19 November 2021

HERITAGE RESPONSE TO RFI LETTER: ATC ROYAL RANDWICK, NIGHT RACING SSD-8706 S

This letter has been prepared to respond to the built (European) heritage elements of the Request for Additional Information received from the Department of Planning, Industry and Environment (DPIE) on 17 August 2021. The relevant built (European) heritage queries are outlined in the table below along with our responses.

Figure 16 Identification of light columns

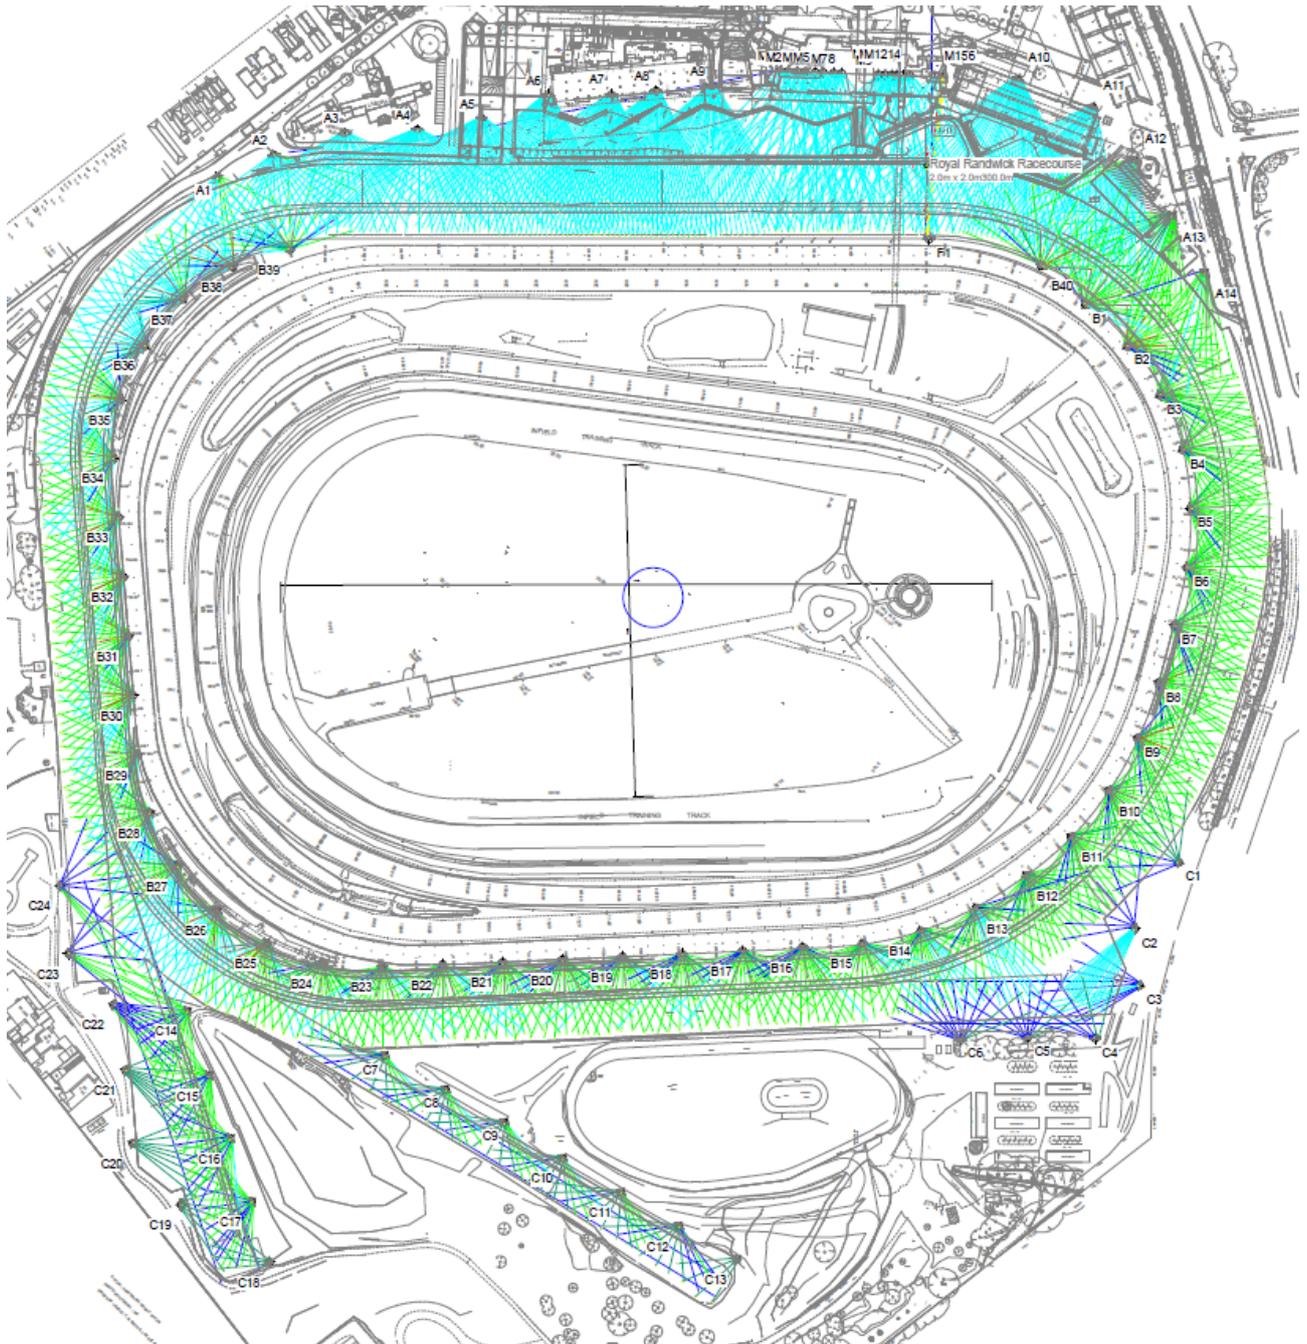
<table><tr><td>Character/ Visual</td><td>Vertical elements added to a visibly flat and horizontal landscape</td><td>As part of the design process all the columns were reduced in height. Use light coloured or galvanised columns and fittings to help them blend into the existing landscape and materials of the site.</td><td>Reduced visual impact</td></tr><tr><td>Visual</td><td>Change to the skyline</td><td>As part of the design process all the columns were reduced in height. Use light coloured or galvanised columns and fittings to help them blend into the existing landscape and sky.</td><td>Reduced visual impact</td></tr><tr><td>Visual</td><td>Contrast to the natural setting of Centennial Park</td><td>Reduce the visual impact of the columns by using light coloured or galvanised columns and fittings to help them blend into the existing landscape, materials of the QEII Grandstand and sky.</td><td>Reduced visual impact</td></tr></table>

<p>It is acknowledged that galvanised iron will be bright at first, but will rapidly dull with age and become less apparent.</p>	Character/ Visual	Vertical elements added to a visibly flat and horizontal landscape	As part of the design process all the columns were reduced in height. Use light coloured or galvanised columns and fittings to help them blend into the existing landscape and materials of the site.	Reduced visual impact	Visual	Change to the skyline	As part of the design process all the columns were reduced in height. Use light coloured or galvanised columns and fittings to help them blend into the existing landscape and sky.	Reduced visual impact	Visual	Contrast to the natural setting of Centennial Park	Reduce the visual impact of the columns by using light coloured or galvanised columns and fittings to help them blend into the existing landscape, materials of the QEII Grandstand and sky.	Reduced visual impact
Character/ Visual	Vertical elements added to a visibly flat and horizontal landscape	As part of the design process all the columns were reduced in height. Use light coloured or galvanised columns and fittings to help them blend into the existing landscape and materials of the site.	Reduced visual impact										
Visual	Change to the skyline	As part of the design process all the columns were reduced in height. Use light coloured or galvanised columns and fittings to help them blend into the existing landscape and sky.	Reduced visual impact										
Visual	Contrast to the natural setting of Centennial Park	Reduce the visual impact of the columns by using light coloured or galvanised columns and fittings to help them blend into the existing landscape, materials of the QEII Grandstand and sky.	Reduced visual impact										
<p>33. No detail of the size or appearance of the generators has been provided, and it is unclear whether the generators will be housed within some sort of enclosure. The submitted Heritage Impact Statement recommends appropriate screening of the generators is provided in the form of a timber or perforated metal enclosure or fence. However, depending on the appearance of the generators, and whether they will be enclosed, further screening could add to the bulk of the installation. Council recommends details of the generators and proposed screening are provided for assessment.</p>	<p>The generators will be screened behind an enclosure which has a natural timber finish (see below for an example image). We have recommended that vegetation screening also be applied commensurate with the landscaped character of the place, to soften the visual impacts of these elements. Given the nature of operations across the site, the proposed generators are not considered incompatible with the use of the place, and the proposed screening measures will assist in reducing their visual appearance.</p>

Figure 21 Indicative layout for proposed temporary diesel generators and MSB

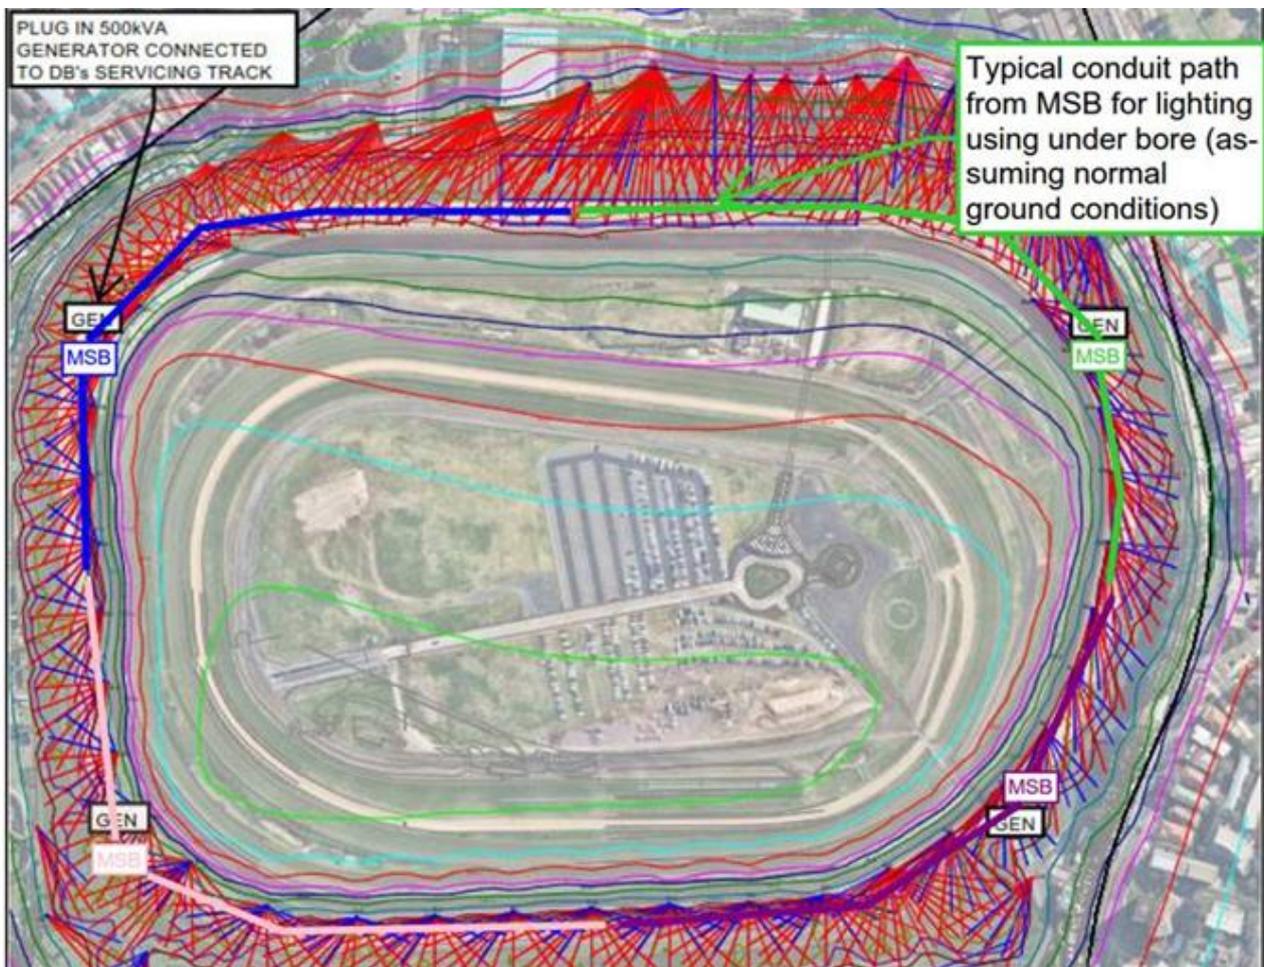
<p>34. Notwithstanding the size and appearance of the generators, Council recommends that the generators not be used and alternative power sources be provided for trackside lighting.</p>	<p>Noted.</p>
